Land fronting, Turnbull Road, Fradley, Lichfield

**Application by Massey Limited for the variation of Condition 2 of planning permission
REF: 18/O1693/FUL**

This Application is for variation of Condition 2 of planning permission 18/O169/FUL, 28th October 2020. That planning permission is for the erection of 8no. dwellings and associated works.

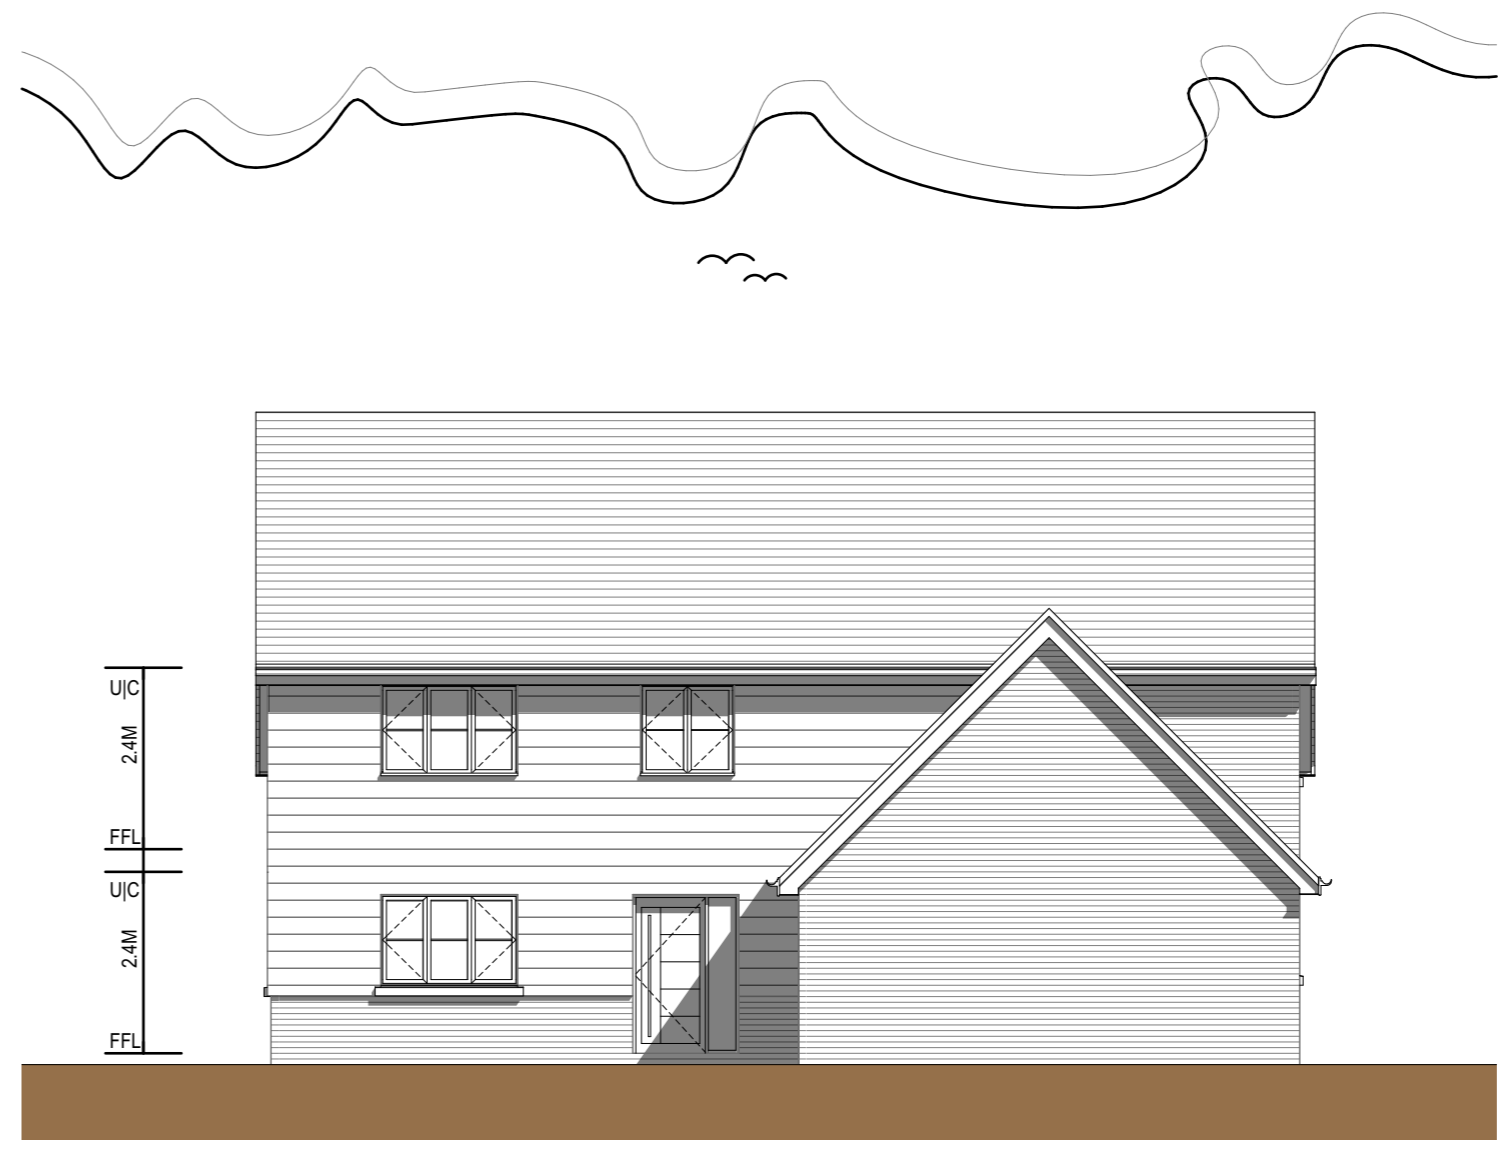
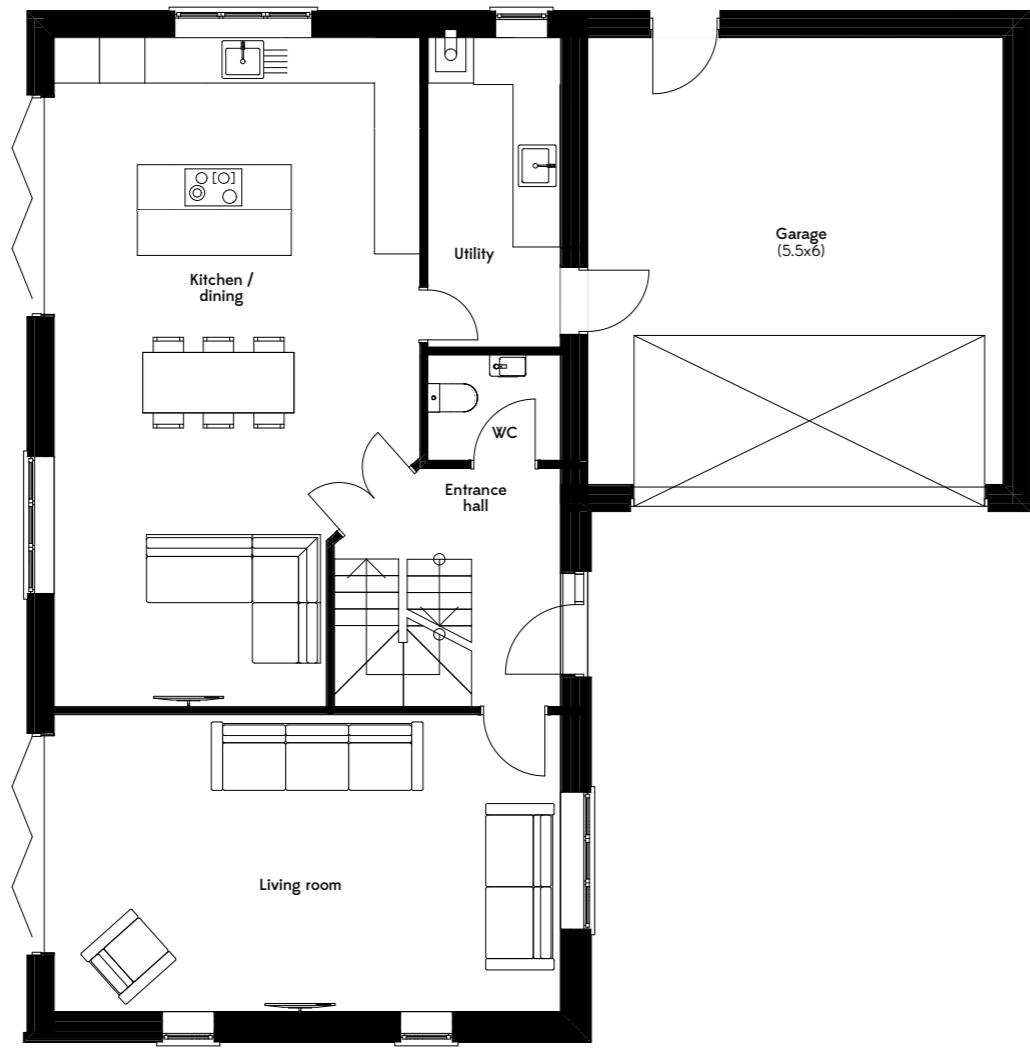
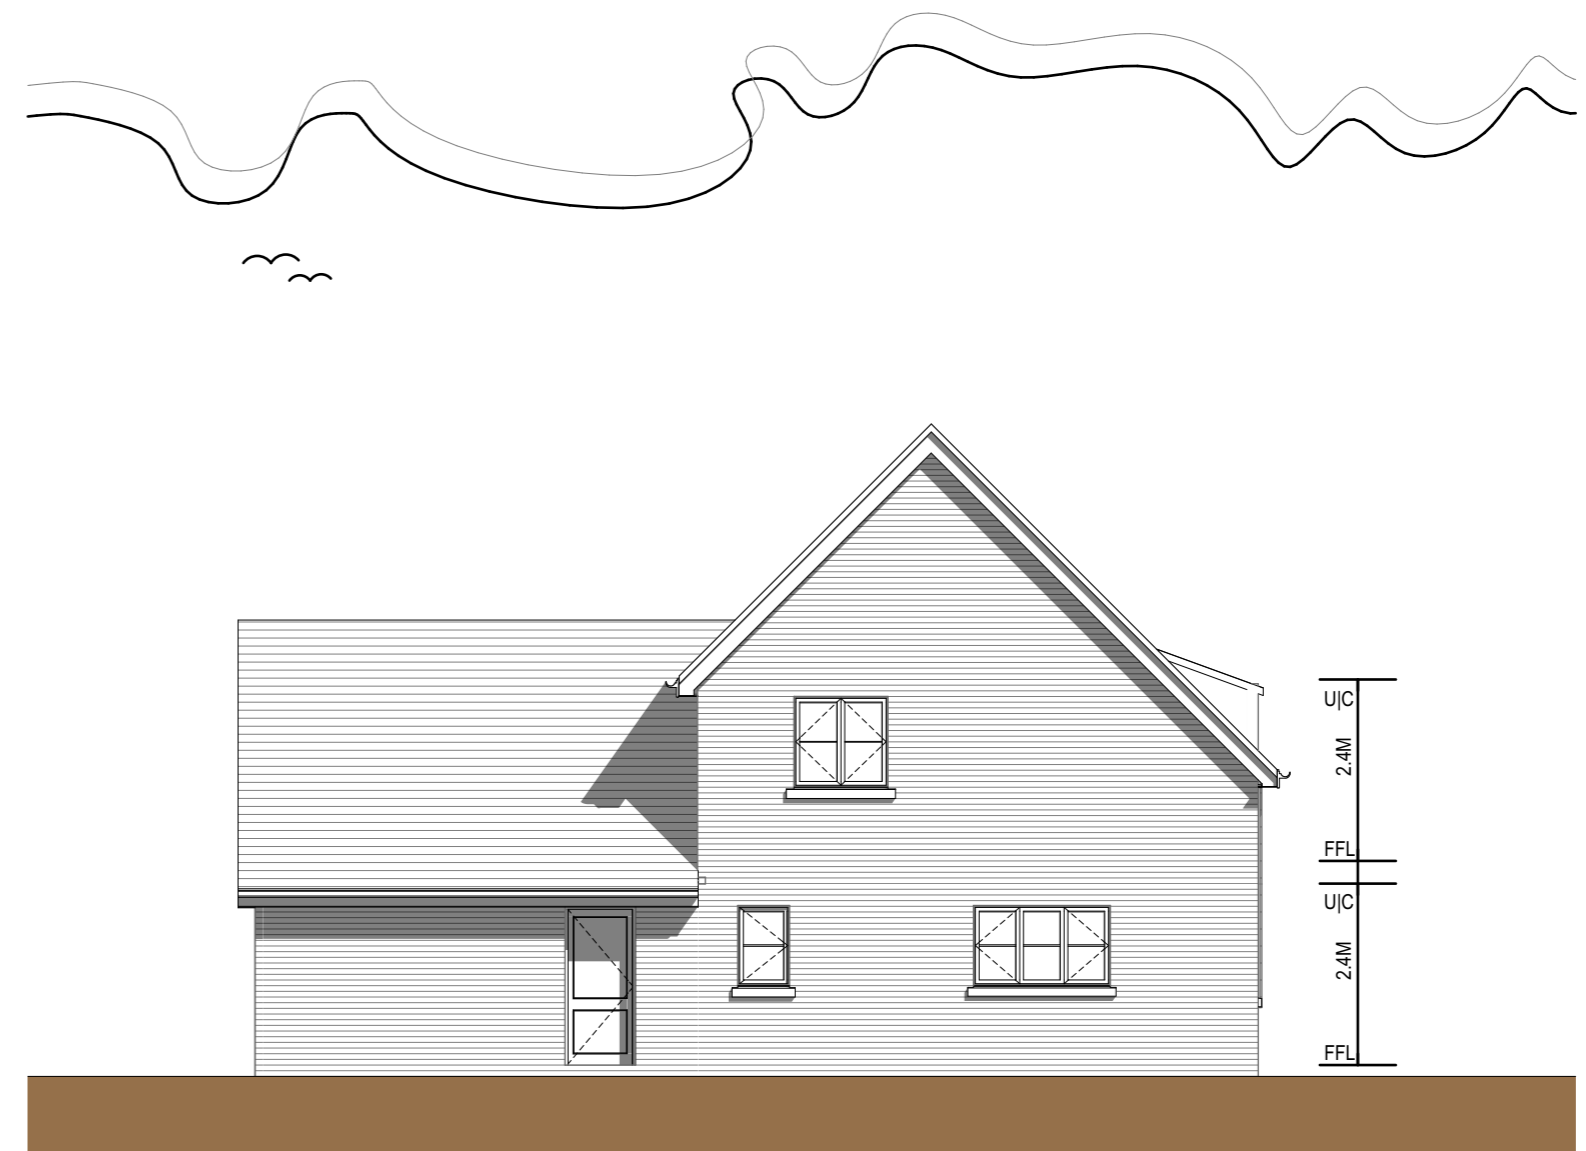
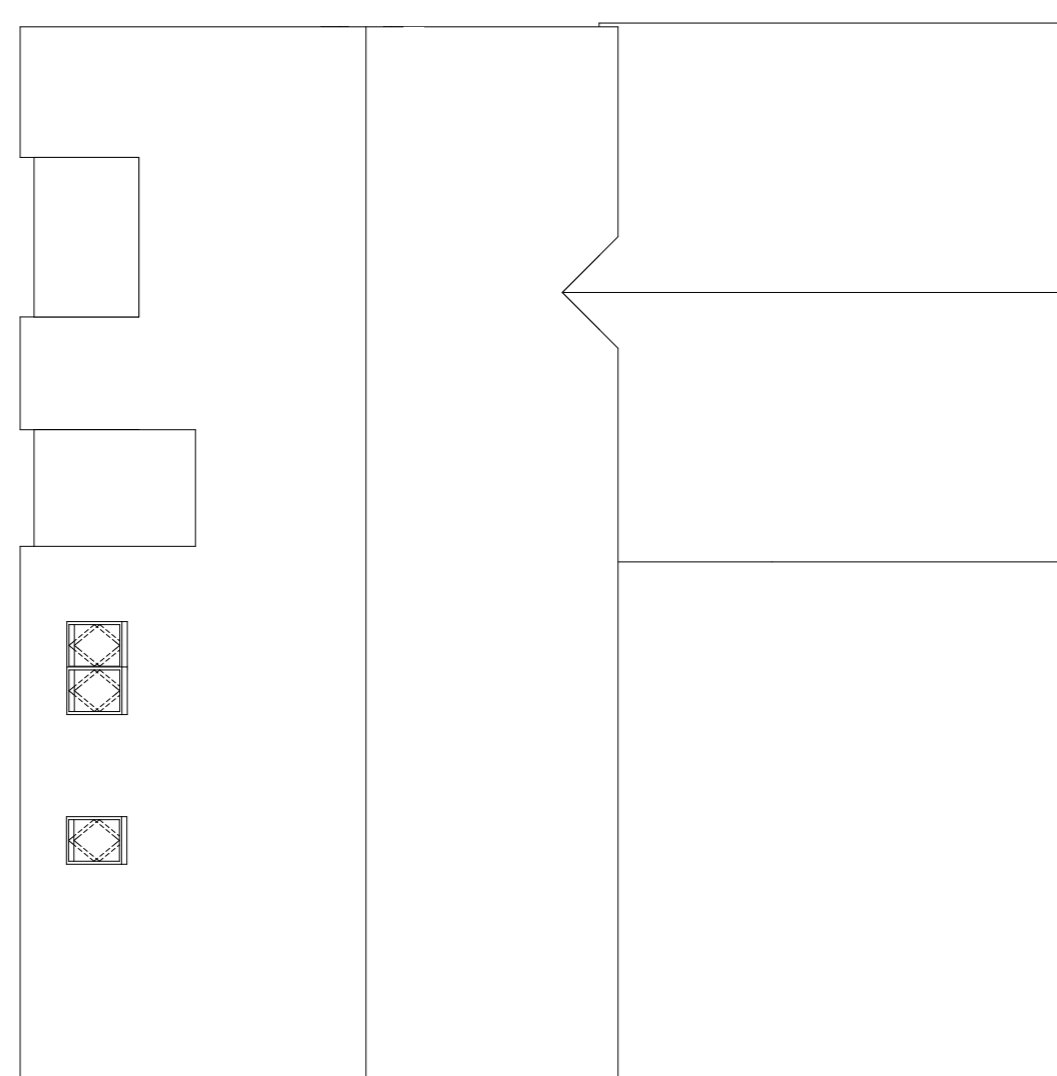
House Type 4

- GIA reduced from 235sqm to 172sqm.
- Double height glazed entrance omitted.
- Overall width of house reduced. Internal layout revised to suit.
- Number of bedrooms reduced from 5 to 4.
- Log stove flue omitted.
- Eaves height of roof above garage lowered.
- Steps in plan on rear elevation omitted.
